CITY OF ALBUQUERQUE

Re: Bernalillo County Animal Care and Resource Center
3001 2nd St., NW
Traffic Circulation Layout
Engineer's/Architect's Stamp dated 12-4-15 (M13-D005)

Based upon the information provided in your submittal received 1-7-16, the above referenced plan cannot be approved for Building Permit until the following comments are addressed:

A1 ARCHITECTURAL SITE PLAN
1" = 30'-0"

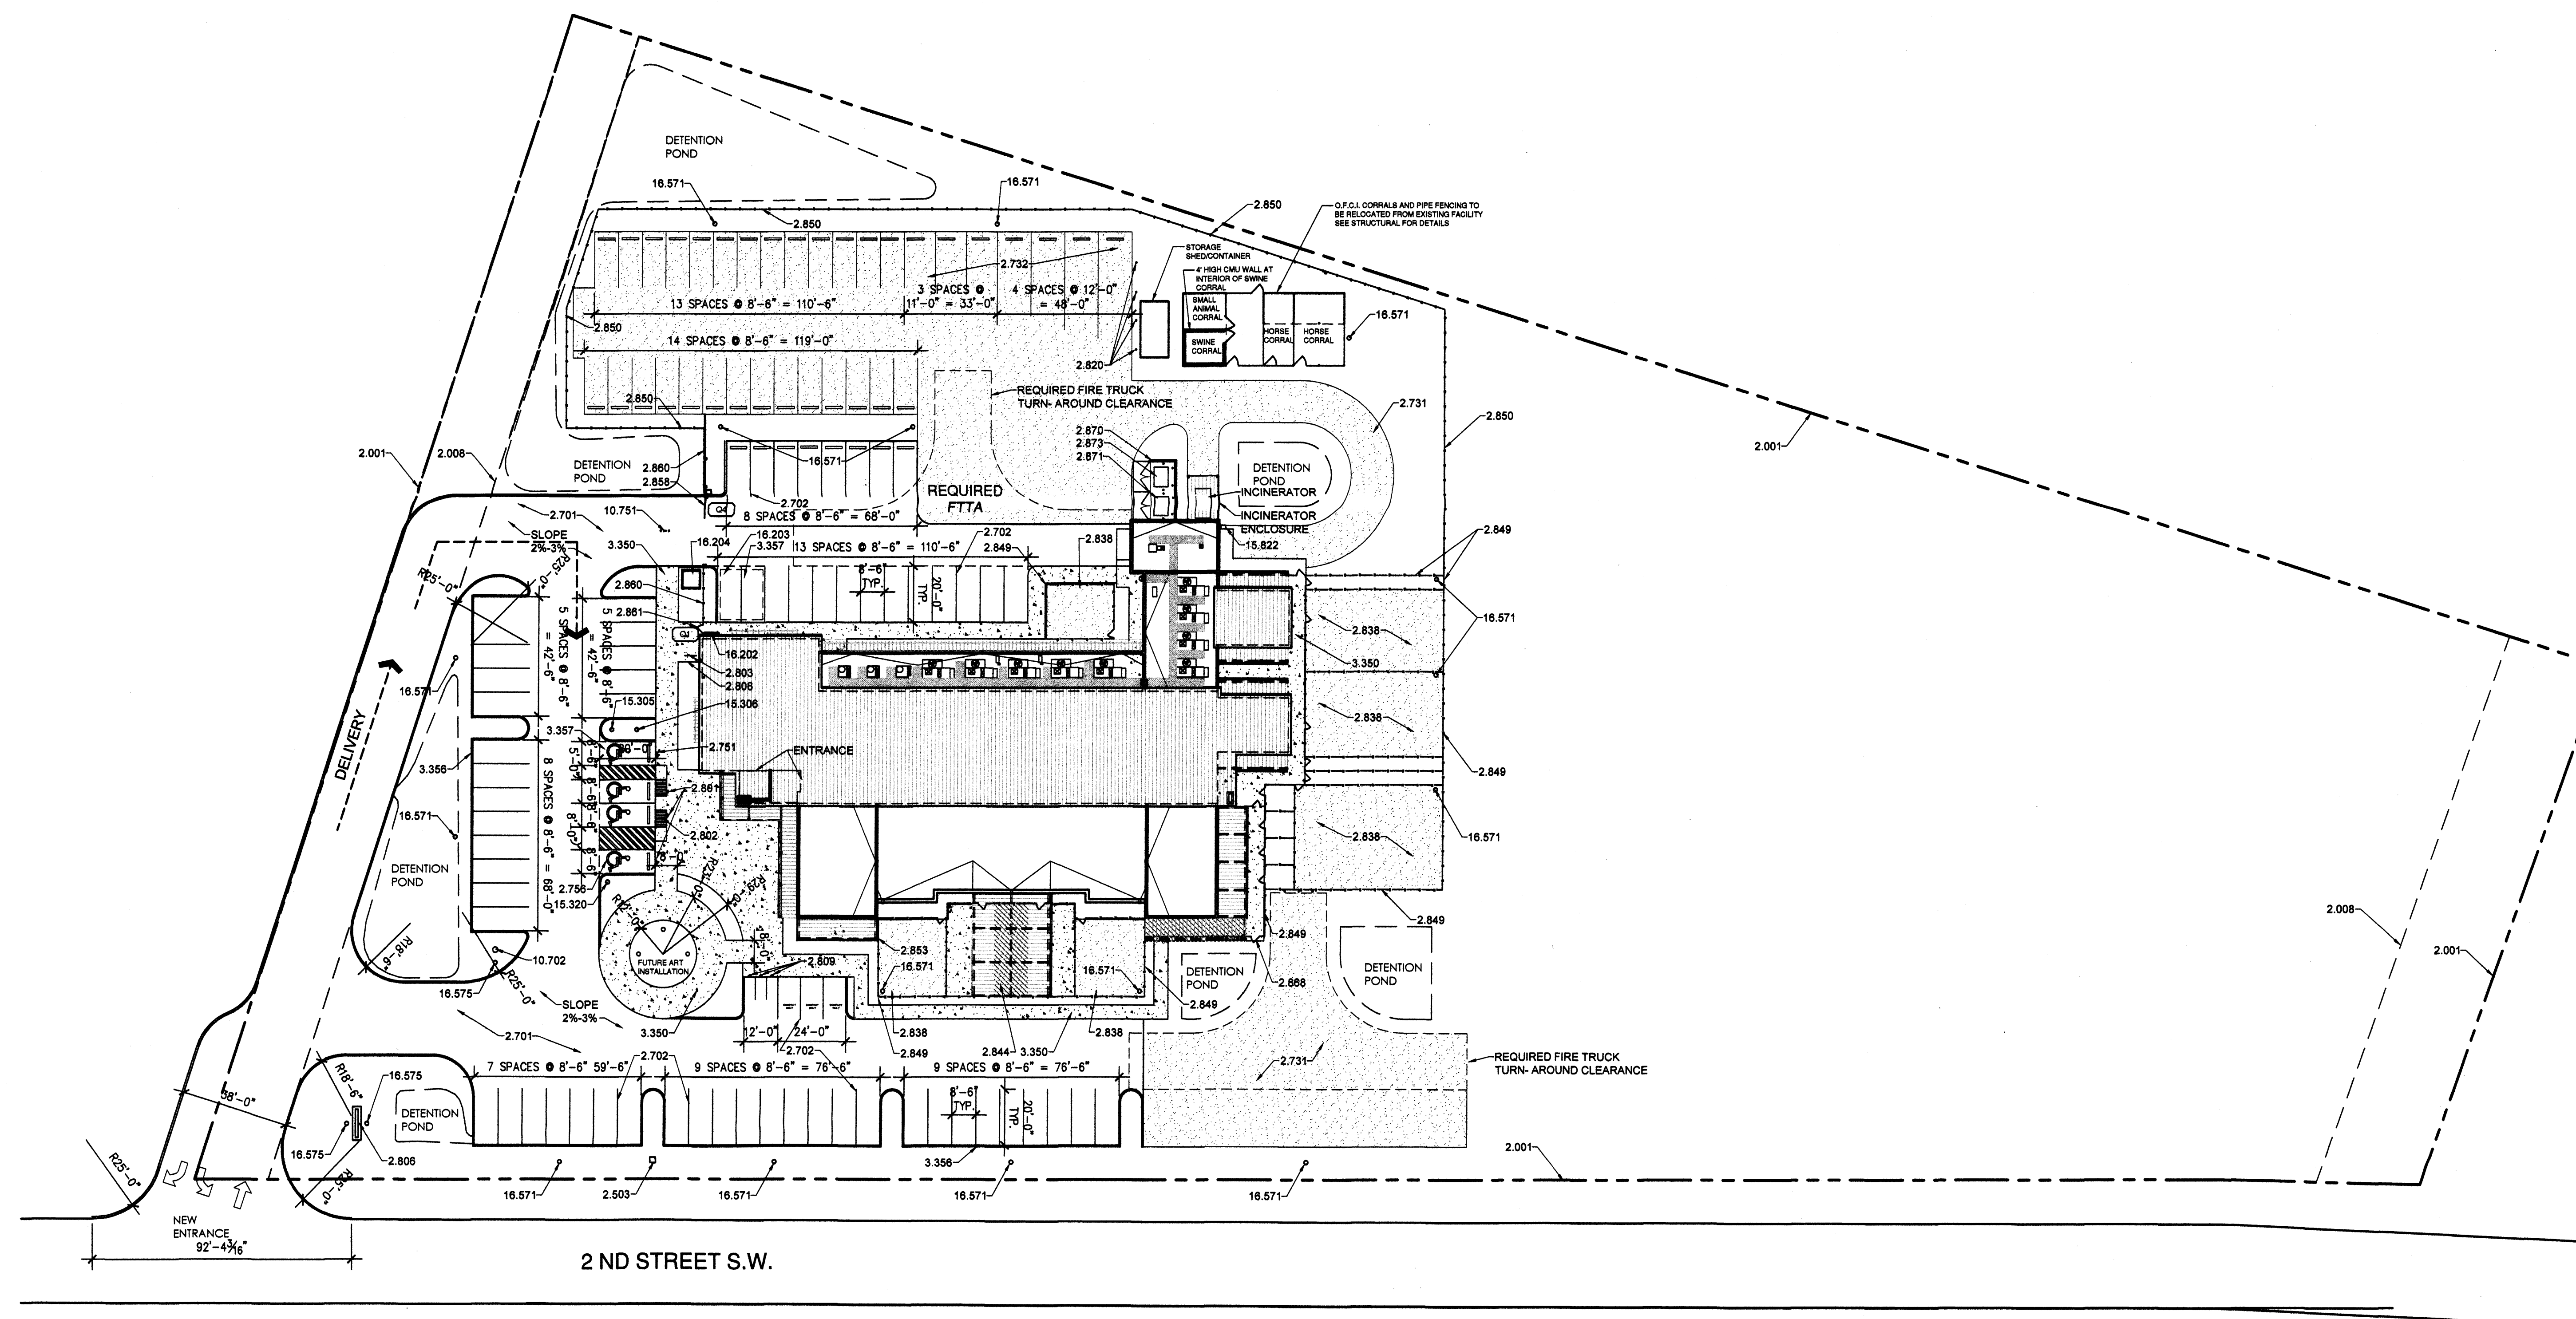
1. Please show a vicinity map showing the location of the development in relation to streets and well known landmarks.
2. List the number of parking spaces required by the zoning code as well as the proposed number of parking spaces.

3. The parking spaces labeled in the same location as a concrete pad for generator cannot be counted in the total parking space calculations.
4. Please identify all existing buildings, doors, structures, sidewalks, curbs, drive pads, walls and anything that influences the parking and circulation on the site.

5. Identify all existing access easements and rights of way with dimensions.
6. Identify the right of way width, medians, curb cuts, and street width on 2nd St.

7. Please dimension the distance between all abutting parking spaces.
8. Please list the width and length for all parking spaces.
9. Show all drive aisle widths and radii.

10. The ADA accessible parking sign must have the required language per 66-7-352.4C NMSA 1978 **"Violators Are Subject to a Fine and/or Towing."**
11. The ADA access aisle shall have the words **"NO PARKING"** in capital letters, each of which shall be at least one foot high and at least two inches wide, placed at the rear of the parking space so as to be close to where an adjacent vehicle's rear tire would be placed. (66-1-4.1.B NMSA 1978)

12. A five-foot keyway is required for dead-end parking aisles. Please show this detail for all dead-end parking aisles.

13. Per the DPM, a 6 ft. wide ADA accessible pedestrian pathway is required from the HC parking stall access aisles to the building entrances. Please clearly show and dimension this pedestrian walk way.

14. Please detail and call out COA Standard Drawings for ADA ramps to pedestrian walk ways.
15. Provide a min 6" or max 8" high concrete barrier curb or other acceptable barrier between landscaping and parking areas and/or drive aisles. Please call this detail.

16. Service vehicle and/or refuse vehicle maneuvering must be contained on-site; provide a copy of refuse approval.
17. It is not apparent what type of pavement surface is being proposed. A hard driving surface will be required as part of this proposed project for parking area and drive aisles. Please detail the type of engineered surface materials proposed for both the paved and graveled parking spaces and drive isles.

18. Please provide a sight distance exhibit (see the *Development Process Manual, Chapter 23, Section 3, Part D.5 Intersection Sight Distance*). Please show this detail for entrance on 2nd St.

19. Please add the following note to the clear sight triangle: "Landscaping and signage will not interfere with clear sight requirements. Therefore, signs, walls, trees, and shrubbery between 3 and 8 feet tall (as measured from the gutter pan) will not be acceptable in this area."
20. Please include two copies of the traffic circulation layout at the next submittal.
